CITY OF ALBUQUERQUE

December 22, 2011

Re: Gardner Zemke Addition Grading and Drainage Plan
Engineer's Stamp date 12-06-11 (E17/D001)

GRADING & DRAINAGE PLAN - SOUTH HALF

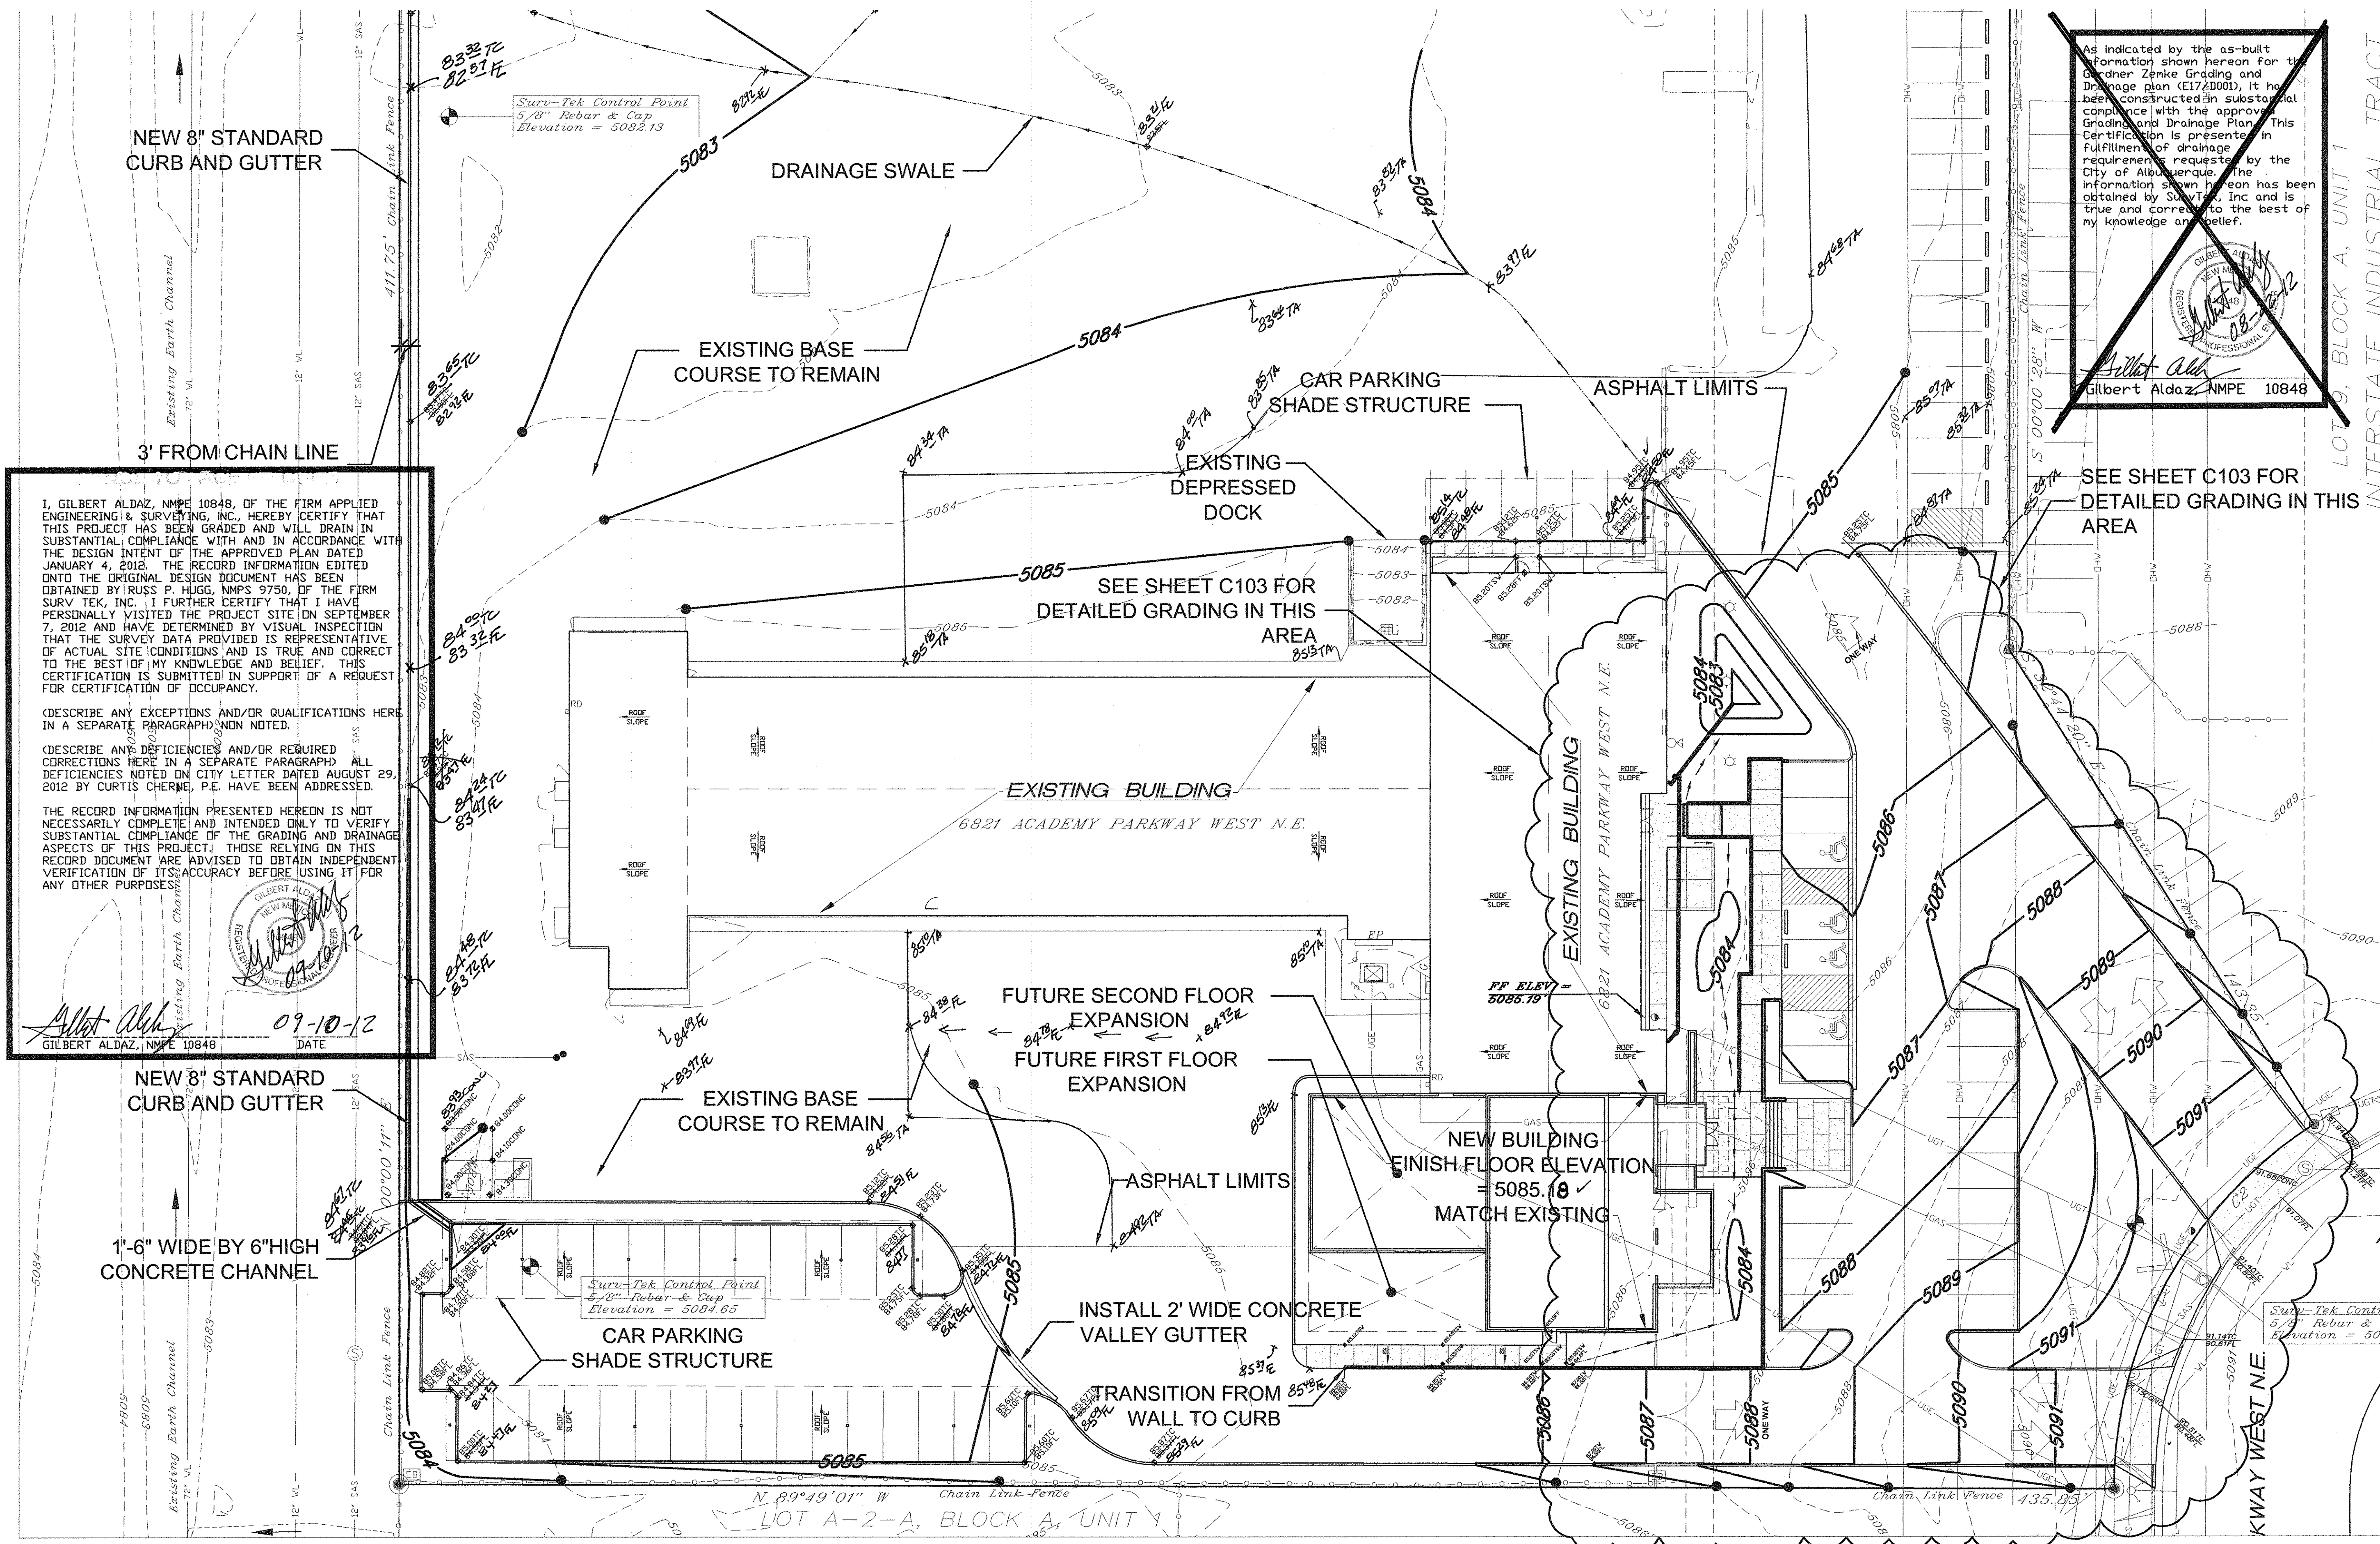
- AMAFCA approval is required for the outfall into the Northern Diversion Channel on the northwest corner of the property.
- It appears that the site will receive significant flows from Academy Parkway through the drives located on the eastern boundary. How will these flows be addressed?
- Please provide roof flows for the shade structure over the parking area on the southwest corner of the lot.
- Place pond volumes on the pond detail located on sheet C104 of the drainage plan.
- Plan must include a Legal Description, FIRM Map, and benchmark designations.
- The legend on the drainage plan should reflect all hatchings, symbols, etc. that are used to describe the site's characteristics. The legend is not legible on some sheets due to its placement.
- All handicap parking areas should maintain a maximum slope of 2%. Please provide spot elevations on the drawings to ensure compliance.
